Further Highway comments

Do you have any further comments in response to the attached RSA & revised tracking drawings.

Client
One Stop Stores Limited
Project
The Former Ship Inn, Aldwick Street, Bognor Regis. PO21 3AP
Title
Site Location Plan with Vehicle Tracking : Articulated Vehicle
Scale
1:500 @ A1
Date
07.01.2020
Drawn By
PAL
Checked By
PM
Project No:
B190031
Drawing No:
B 202
Revision
A

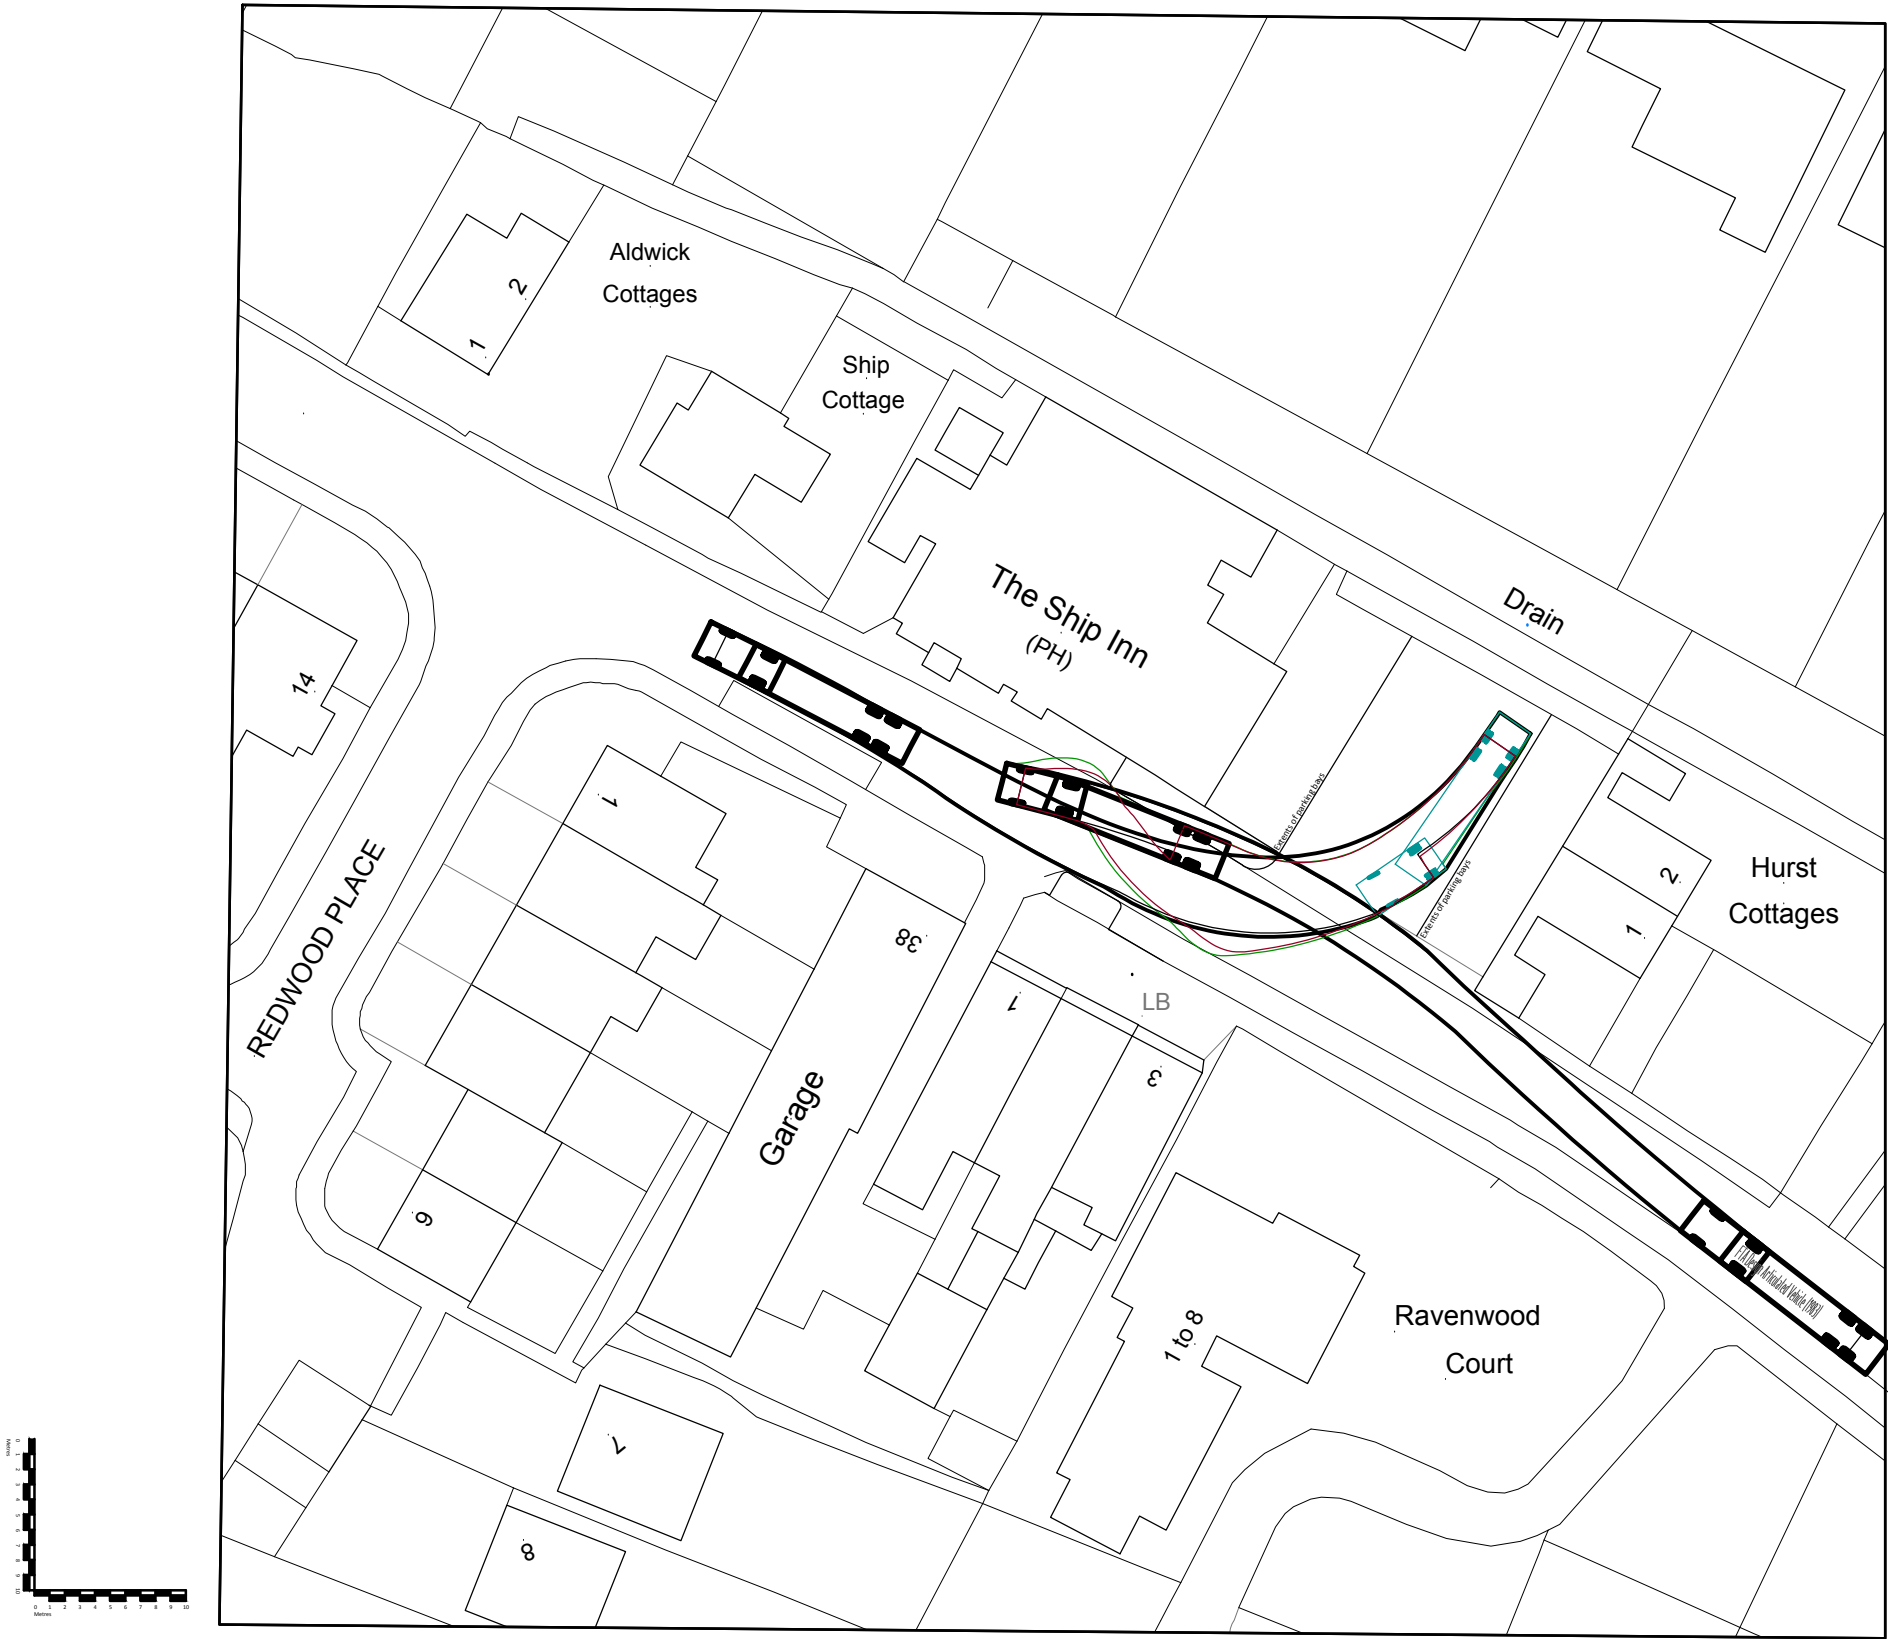
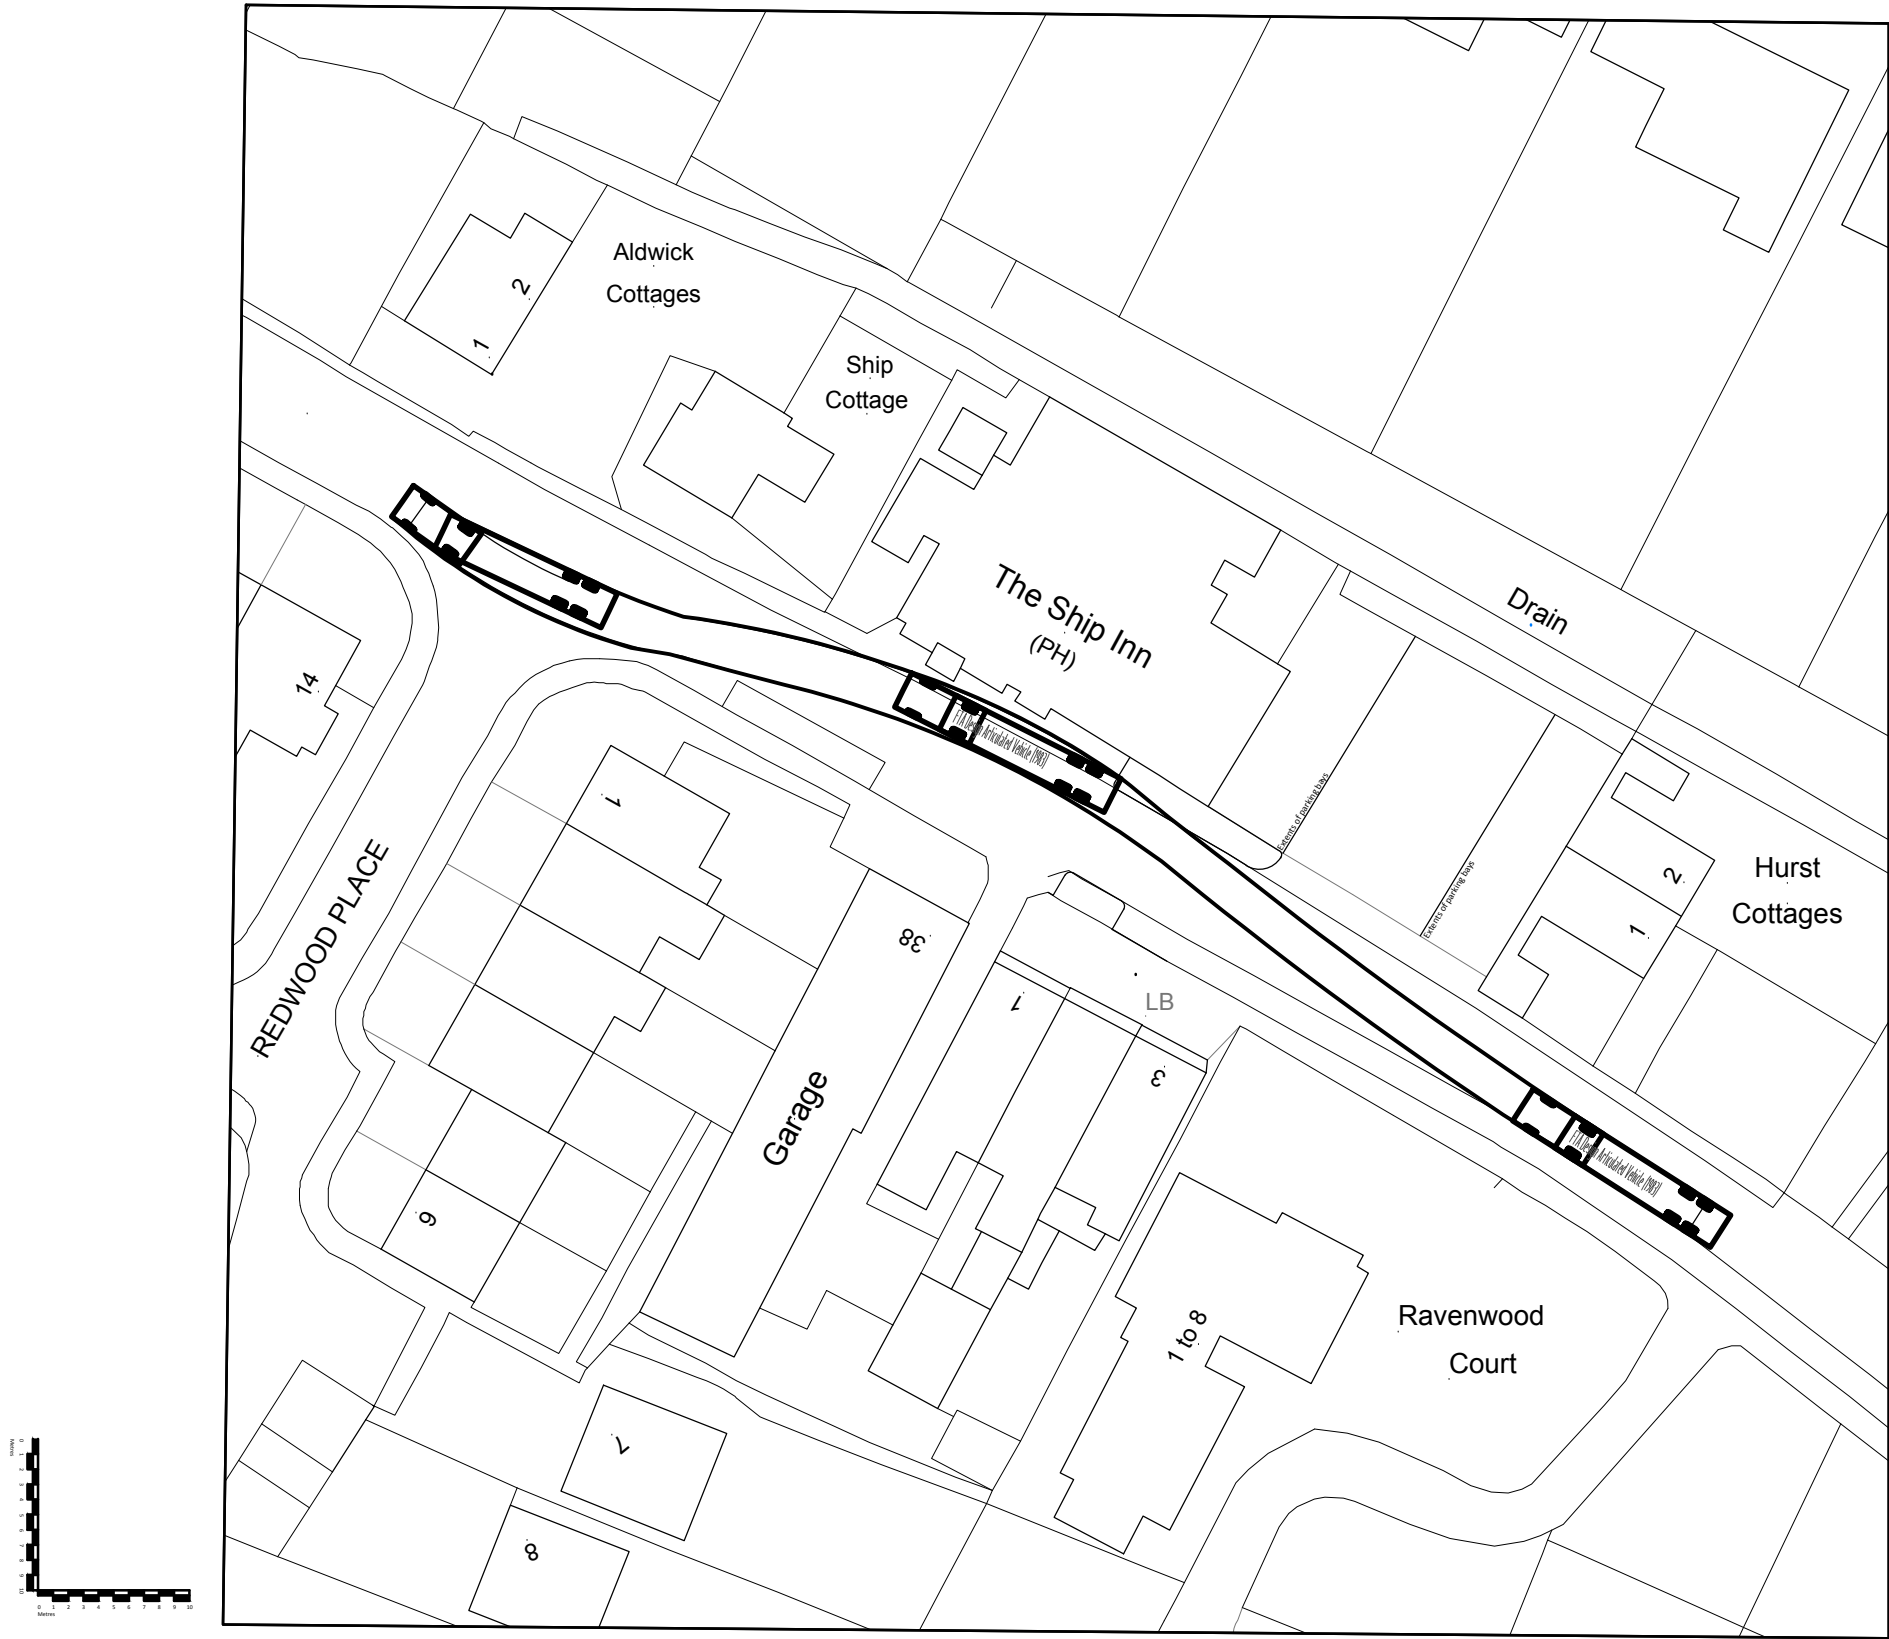
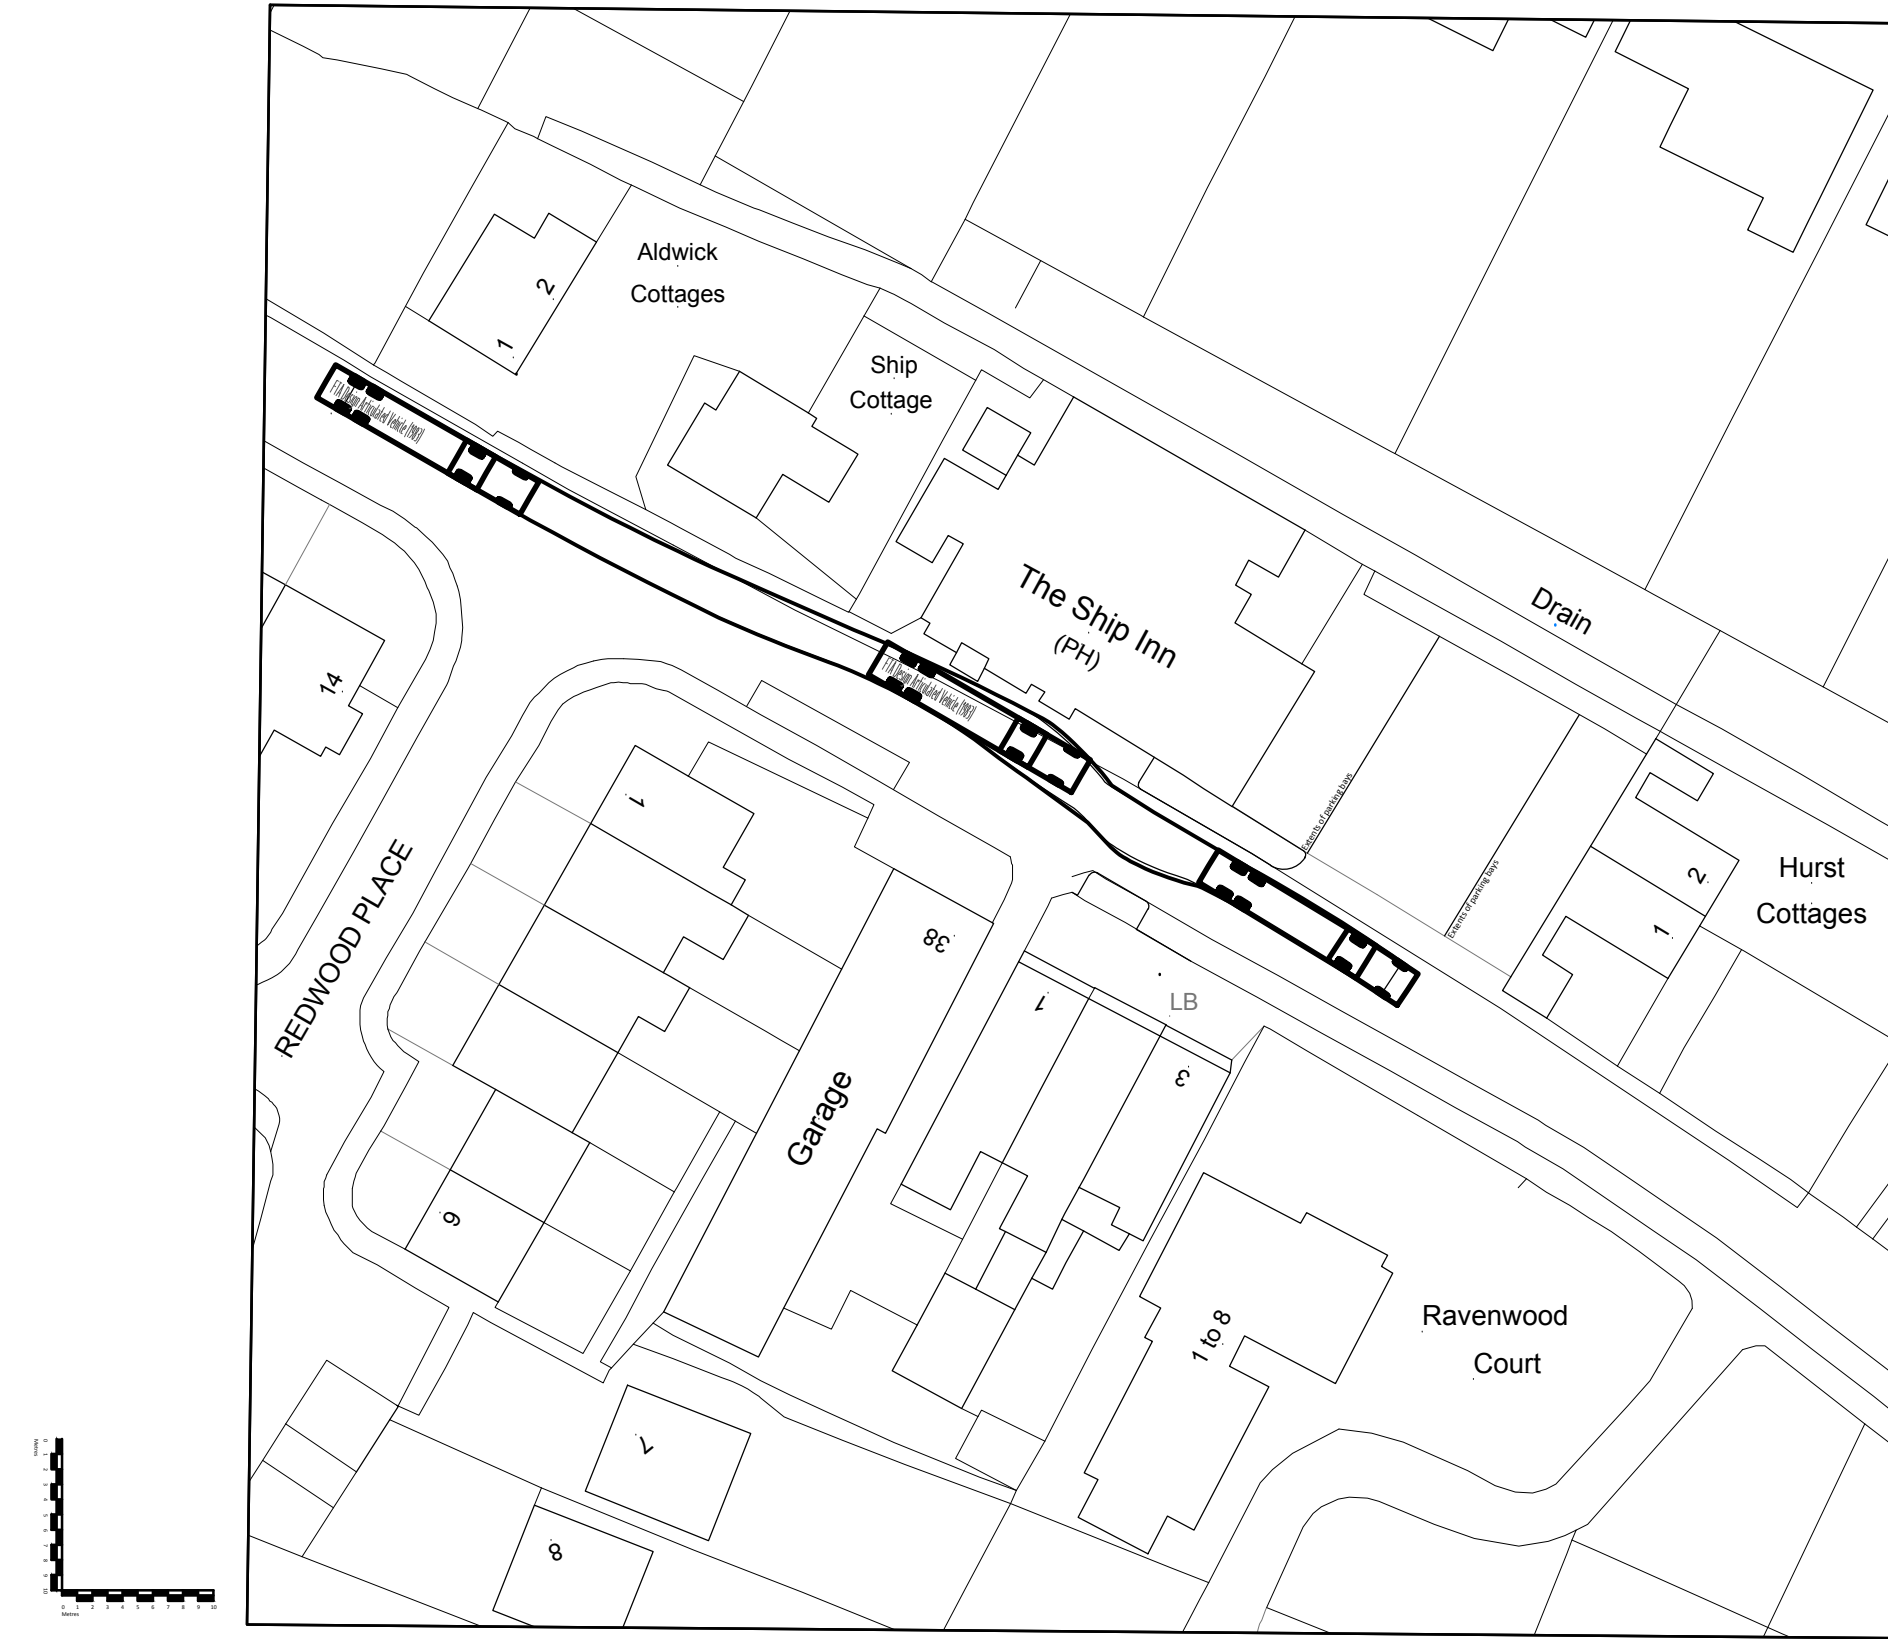
I would also like to highlight that the tracking plans will need to be re-done to be as realistic as possible.

These will need to include the parking bays at the western end of Aldwick Street, adjacent to Goodwood Motors. I notice this is not included in the current diagrams, and neither is the proposed footway with dropped kerb to the north.

Dimensions should also be shown on these diagrams so we can see how wide the carriageway is here as this was highlighted in the RSA.
